**ADC Planning Consultation
Response from the Historic Buildings Adviser**

Application Number	AB/121/12/L
Address	Land adjacent to 84 Maltravers Street, Arundel
Description	Erection of 1 new dwelling.
Case Officer	Anita Gardner
Site Visit	29 February 2012 & 21 November 2012

Elevations & Section

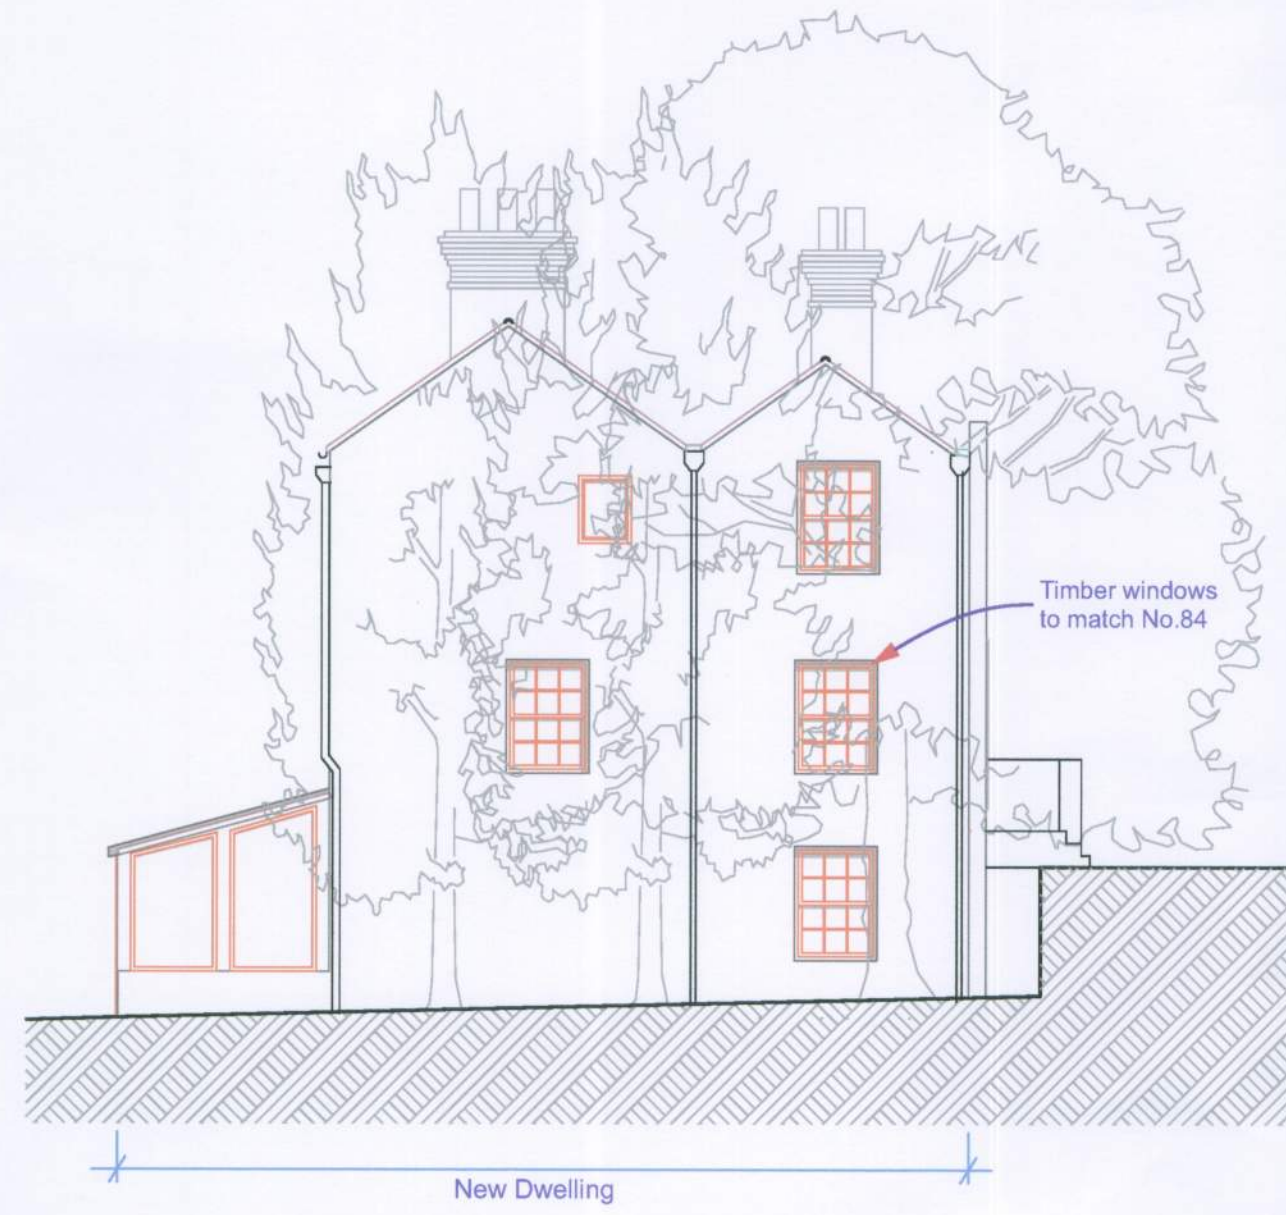
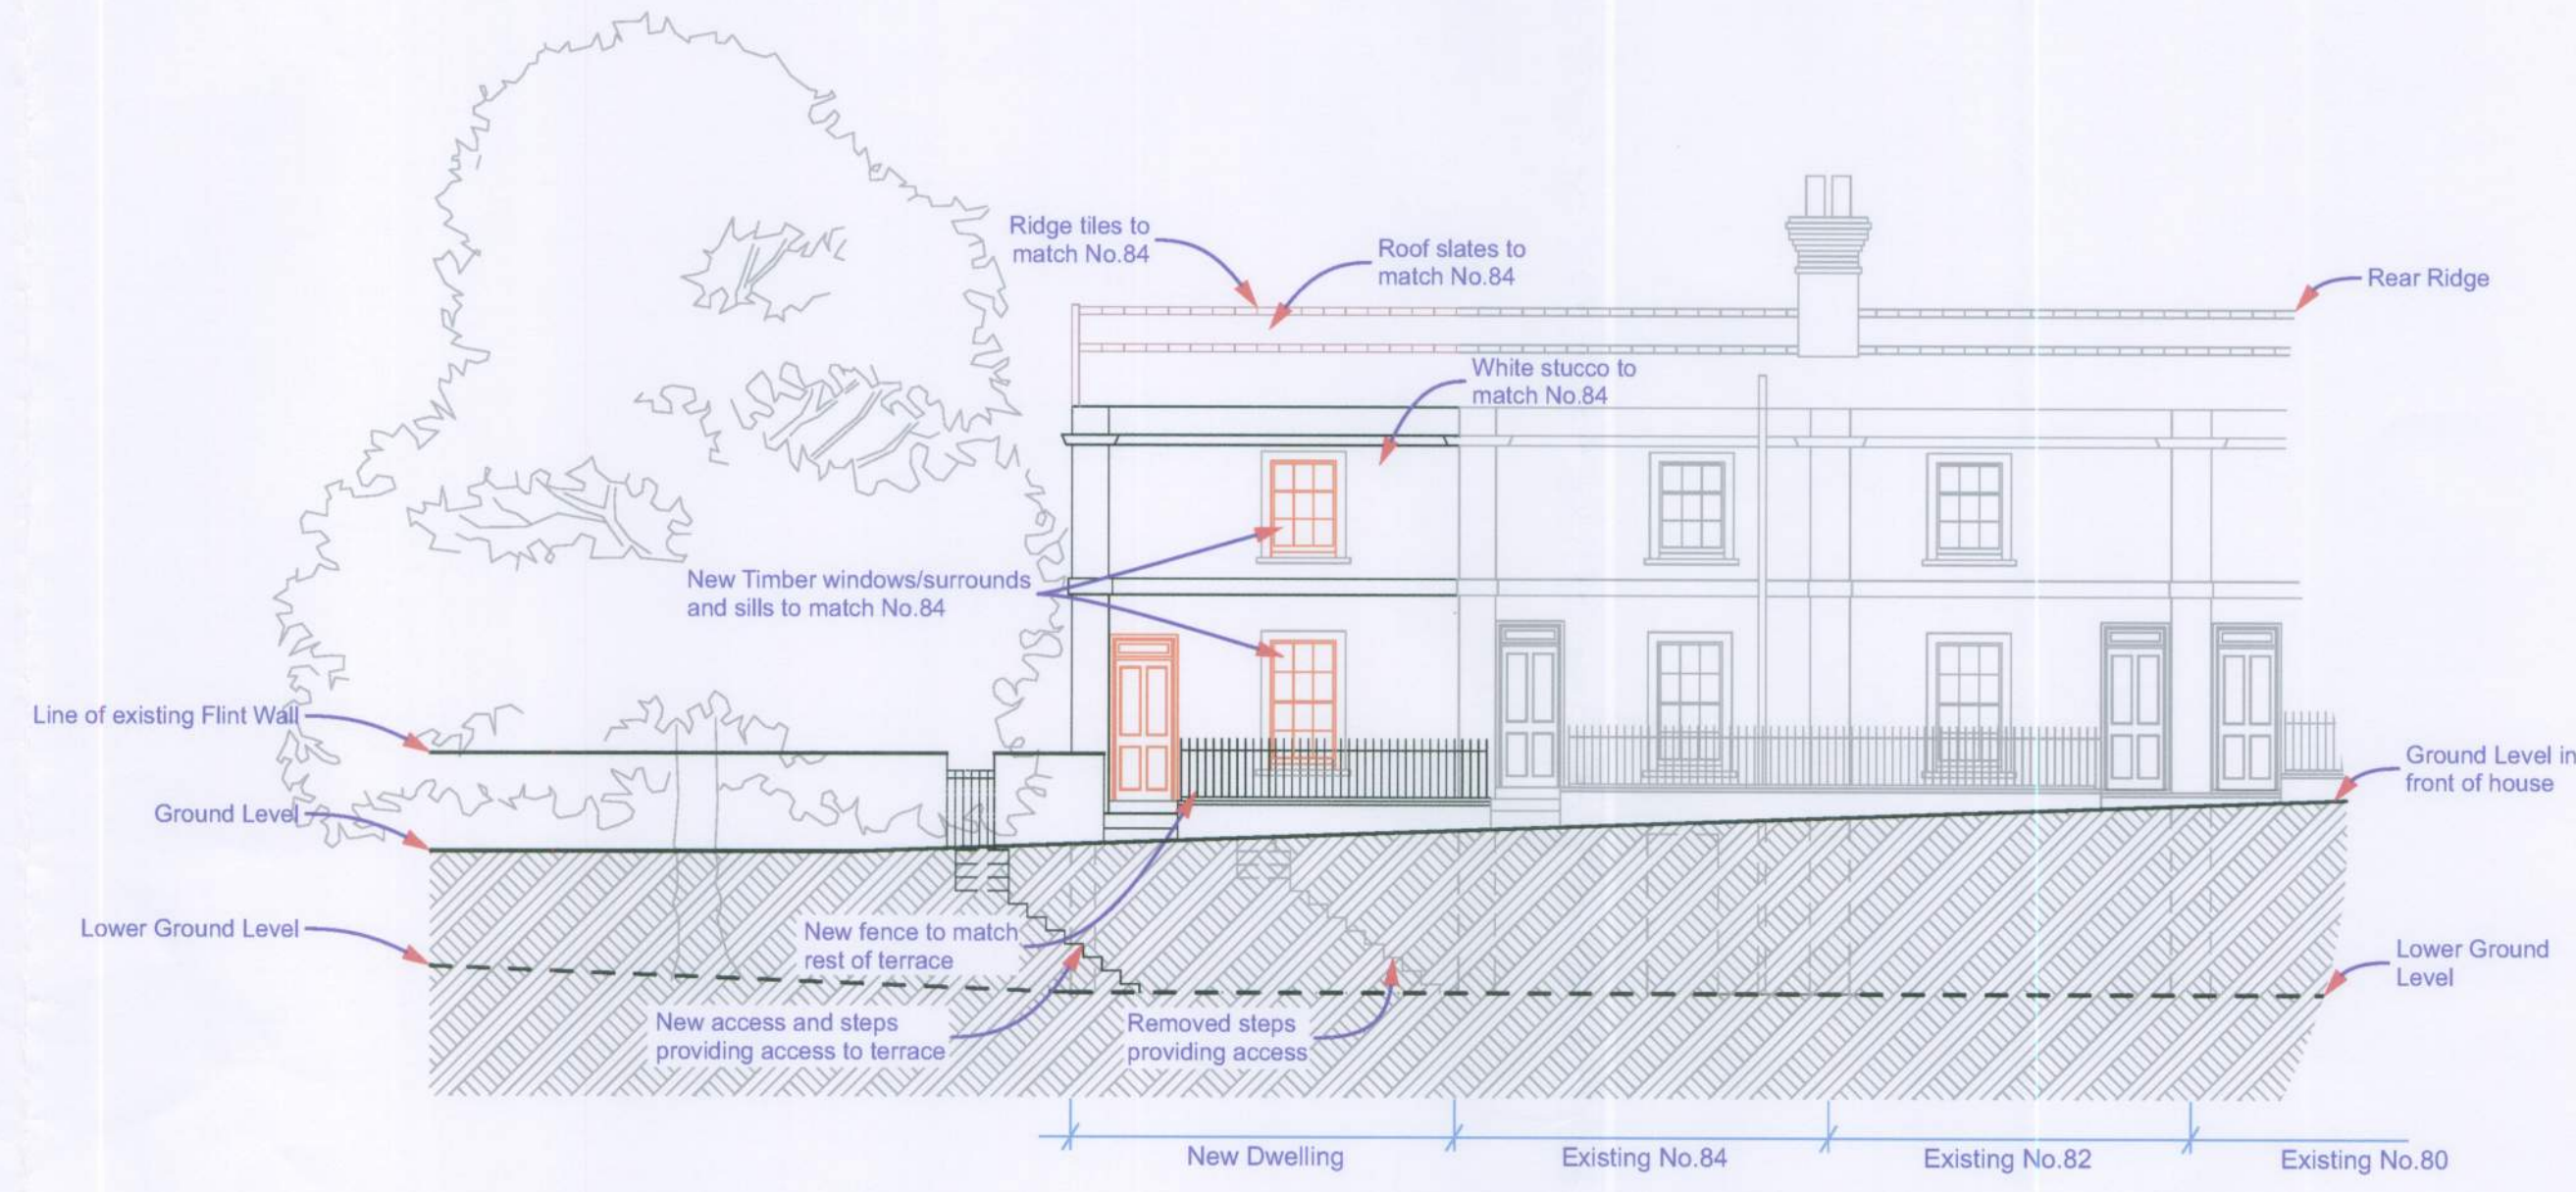
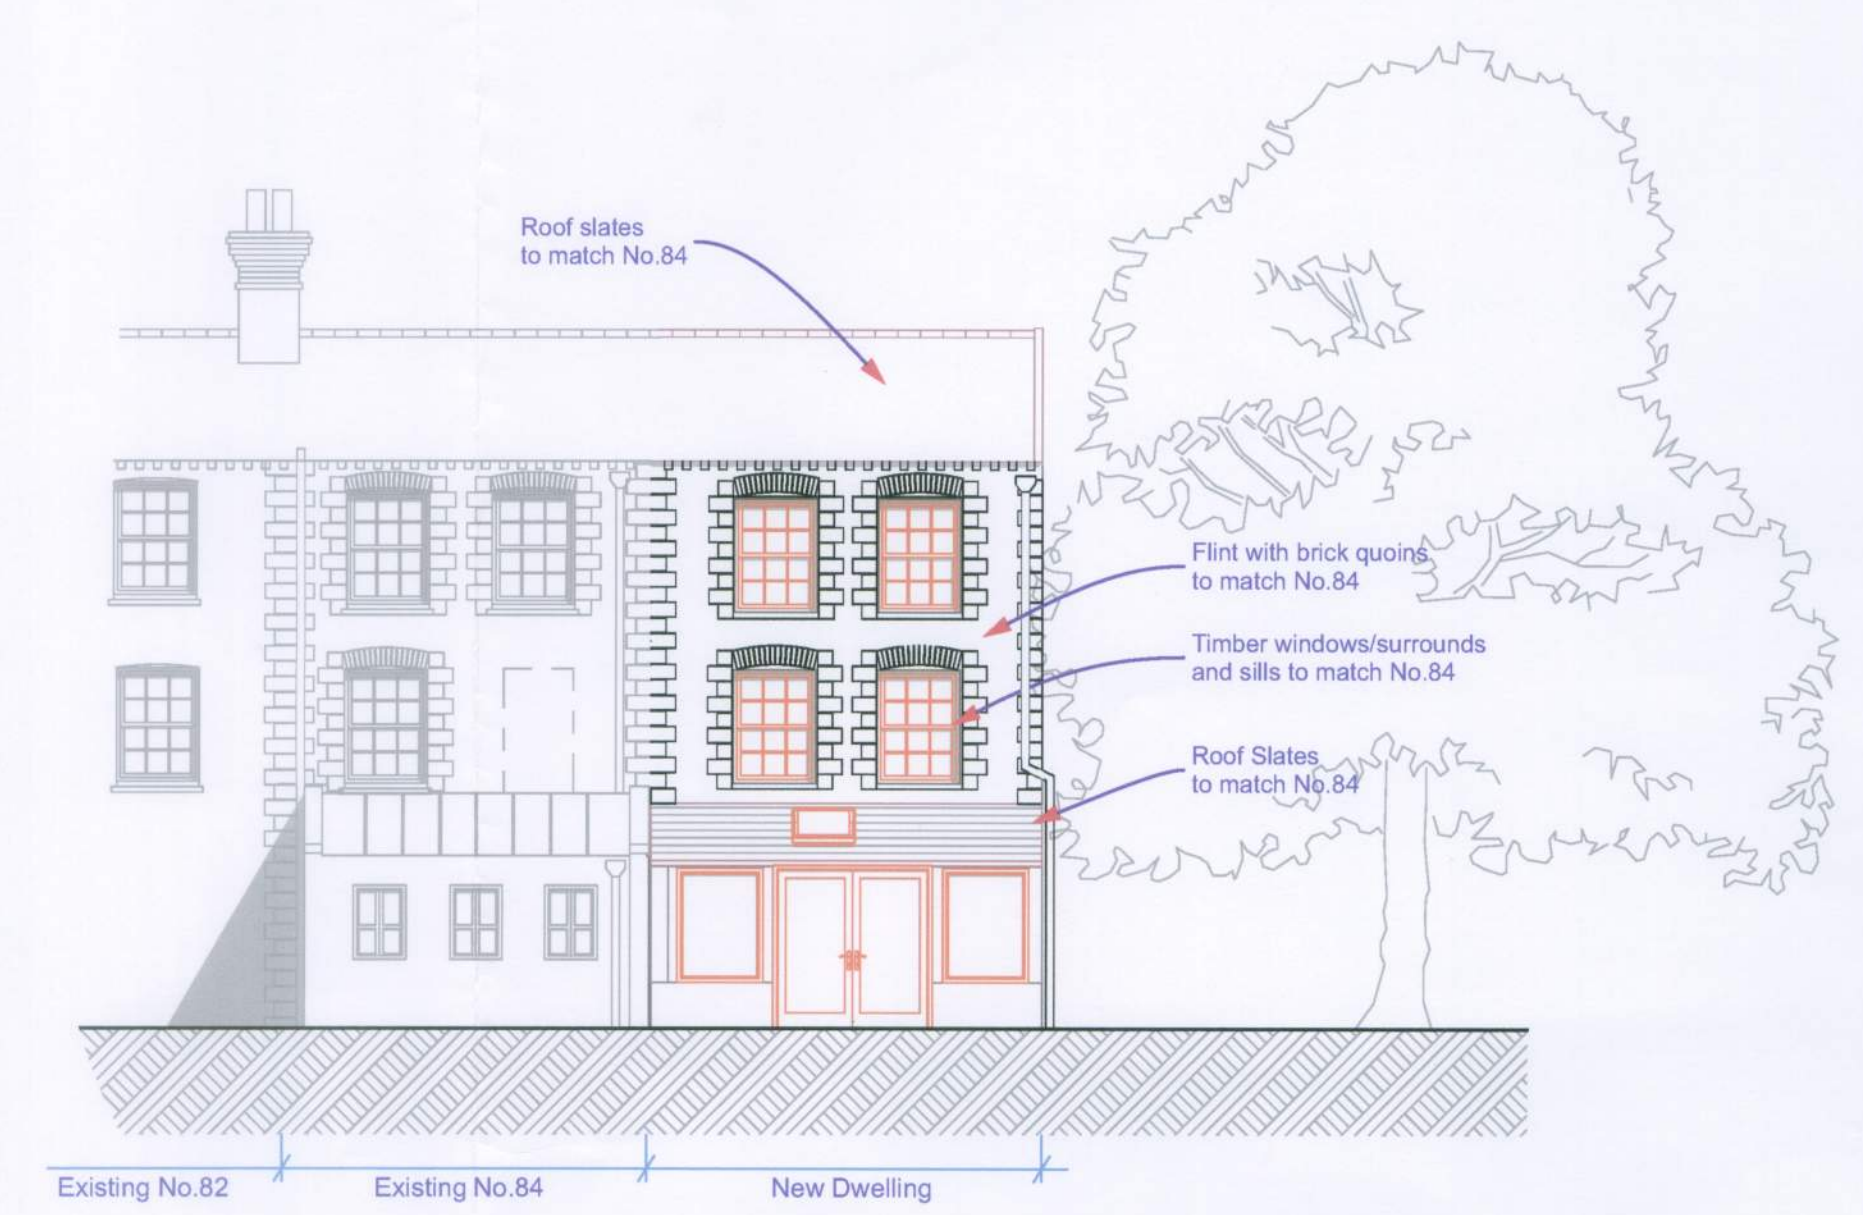
The previous comments also went on to discuss the setback position of the proposed building and the boundary treatment which were seen to compound the above issues. In this scheme they have been changed and the elevation made flush with the listed building, as if this somehow alleviates the problem. Unfortunately, this misunderstands the fundamental concern that any addition to this terrace, however well replicated would be harmful to the historic group

and would undermine its integrity. In this instance the most faithful replication of the façade and frontage would be greatly misleading if not pastiche.

Even if it was an appropriate conservation approach, replication is not achievable here as any new dwelling will require double-glazing to meet SAP calculations. This would alter the window profile and appearance which in turn would be harmful to the broader group. In this instance it would also include a new range of windows on the south west elevation which are not a feature of the current listed building. These would affect the character of the terrace as well as its setting. The windows would be a distraction to the historic façade and at night would offer light spill.
